Modification to Major Project 06_0210

Rozelle Bay Marine Centre

Lots 29 and 30, James Craig Road, Rozelle

Submitted to
Department of Planning
On Behalf of Rozelle Bay Pty Ltd

MP-001-DA

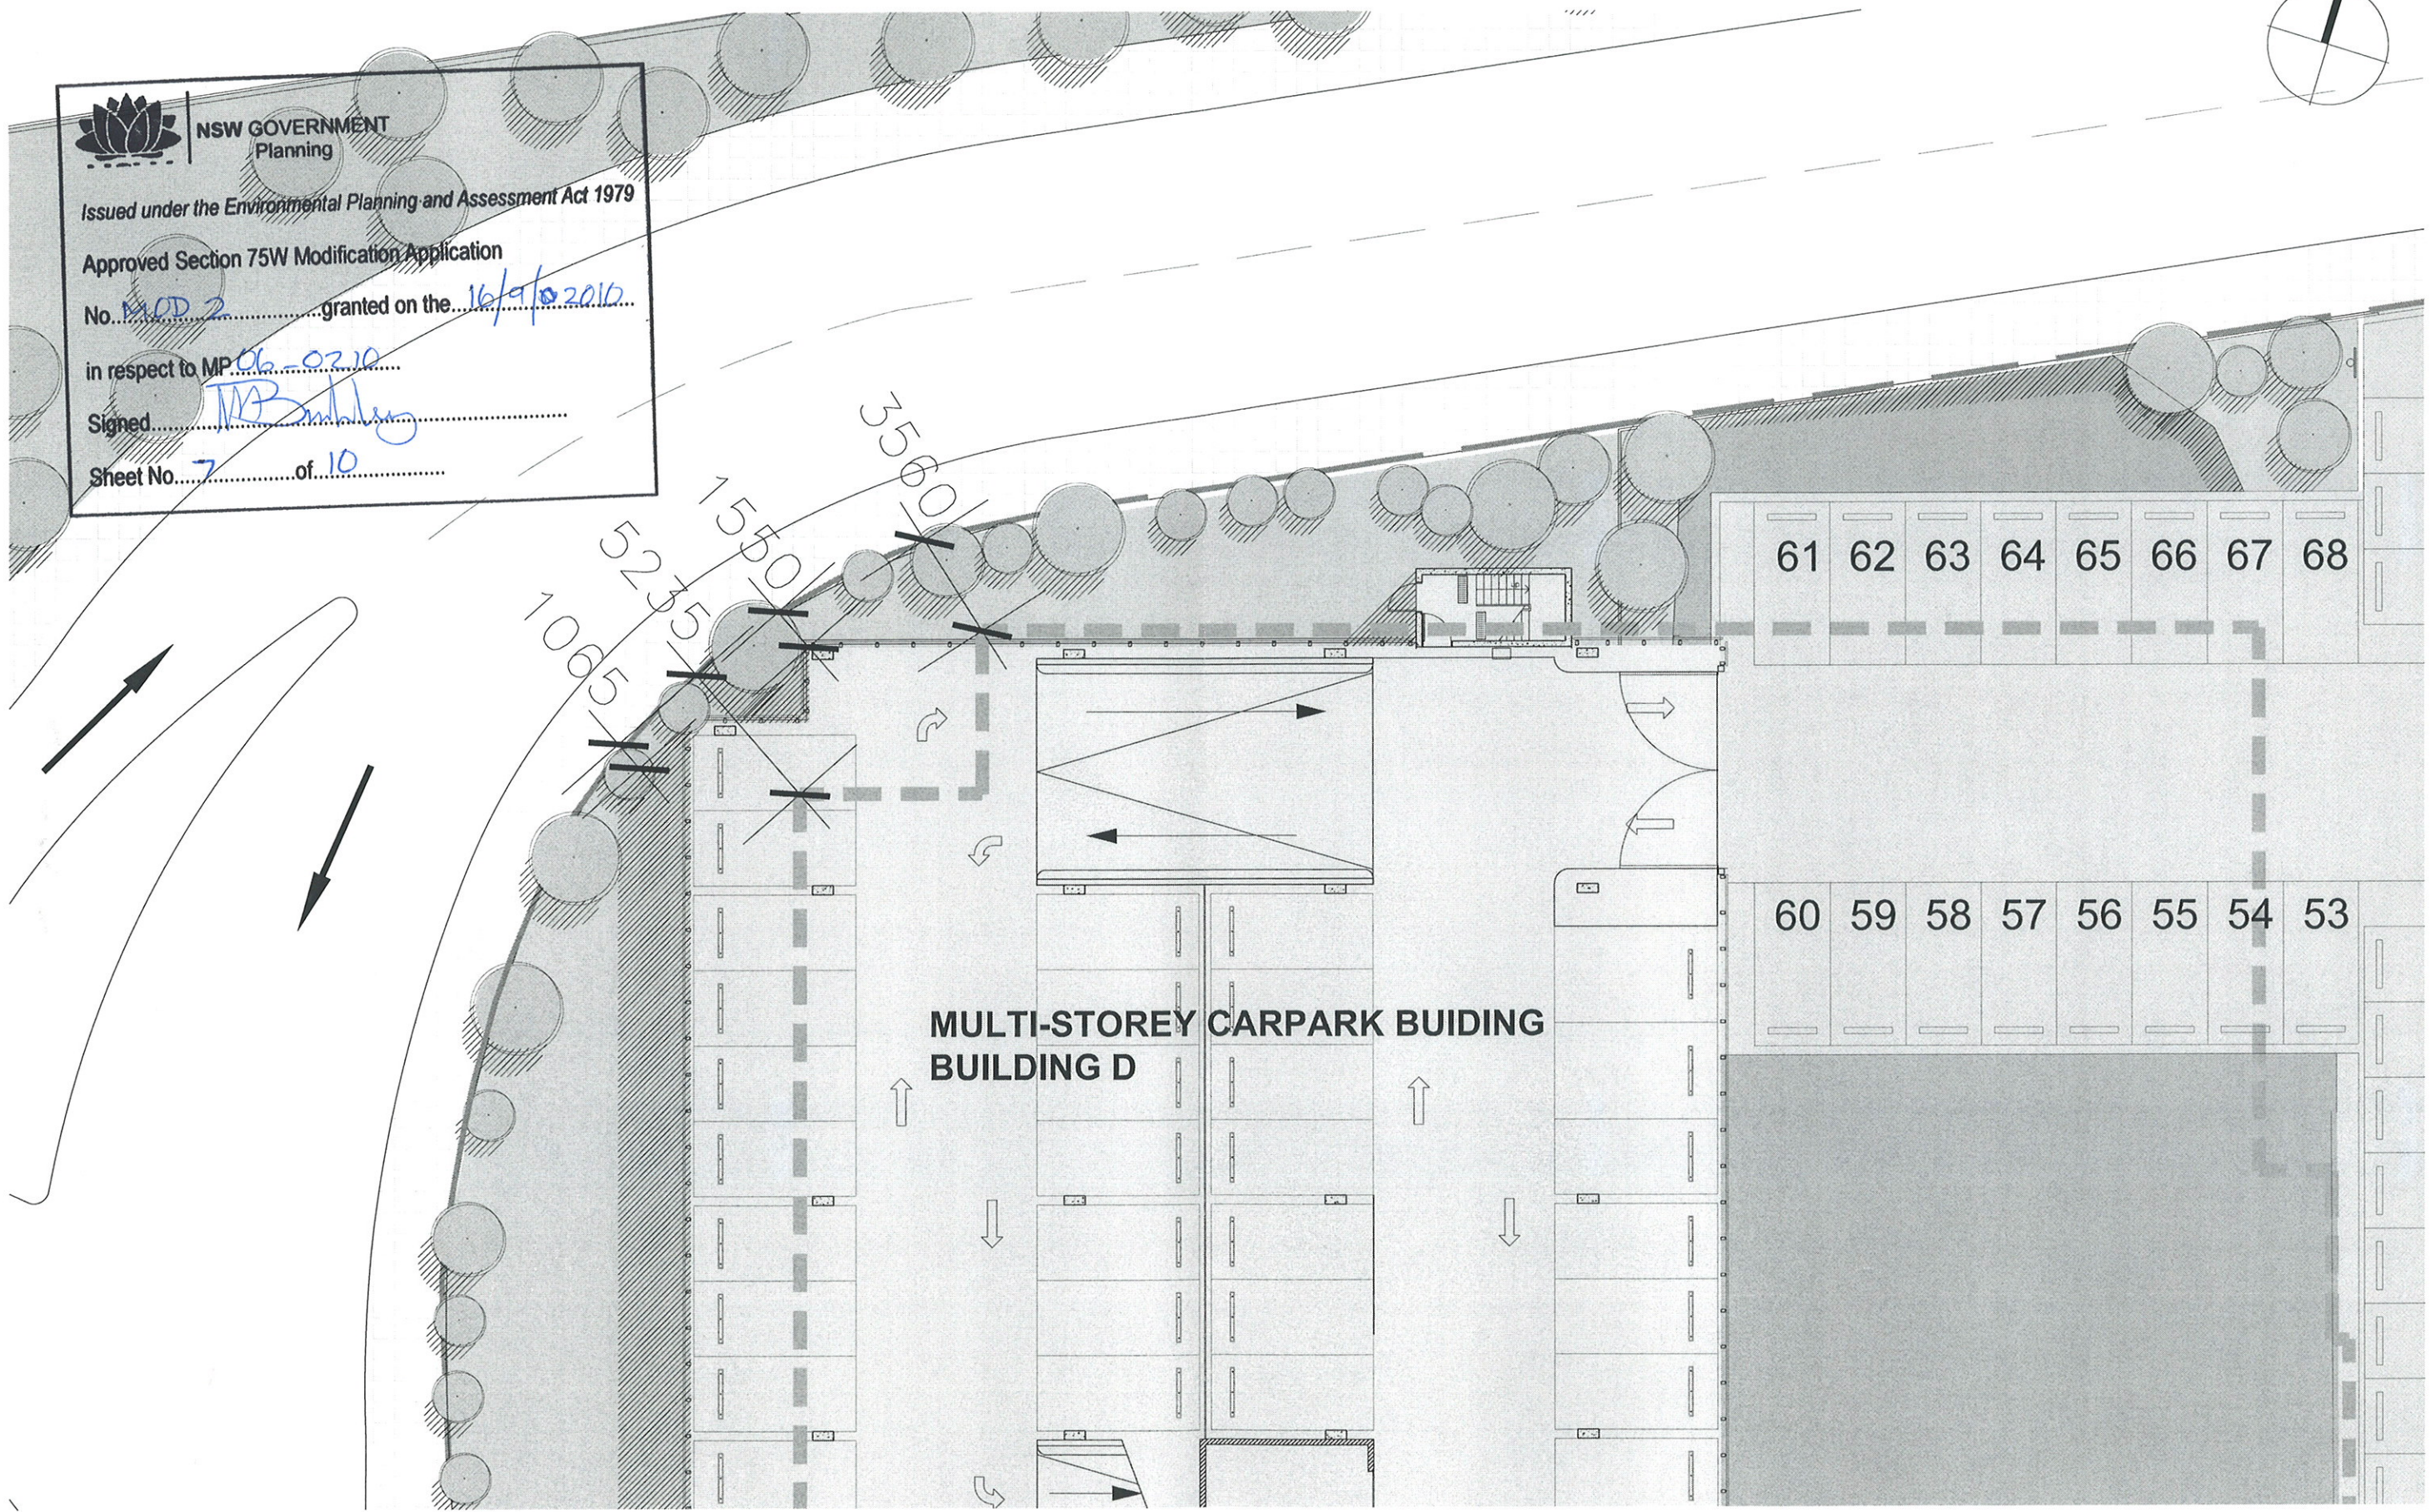
Stage 2 comprises the construction of the multi storey car park and the Eastern Boat Store. The at-grade car parking spaces at the western end of Lot 29 would be temporarily relocated onto Lot 30, whilst the multi storey car park is constructed. When completed the temporary car parking spaces on Lot 29 and 30 will be moved into the multi storey car park. The boats stored on Lot 30 will be stored on the southern and eastern boundaries. Figure 8 illustrates the relocations within the site and Figure 9 illustrates the completed development.

A repositioning of the Western Boat Store slightly to the east is proposed to accommodate new site infrastructure. The repositioned Western Boat Store is detailed on the amended drawings.

The Western Boat Store has been repositioned slightly to the east to accommodate new site infrastructure, including stormwater pipes required to service the new development. The new position of the Western Boat Store also allows for some at grade parking at the north west corner of the building.

Figure 10 below illustrates the repositioning of the Western Boat Store, which increases the buildings setback from the James Craig Road boundary from 1.19m (dashed green line) to 2.09m at the north west corner.

MP-001-DA	Site Plan Final Development	Issue F Jan 2007
MP-011-DA	Site Plan Phase 1 of Stage 1	Issue N October 2009
MP-012-DA	Site Plan Phase 2 of Stage 1	Issue N October 2009
MP-001-DA	Site Plan Stage 2 Final Development	Issue N October 2009
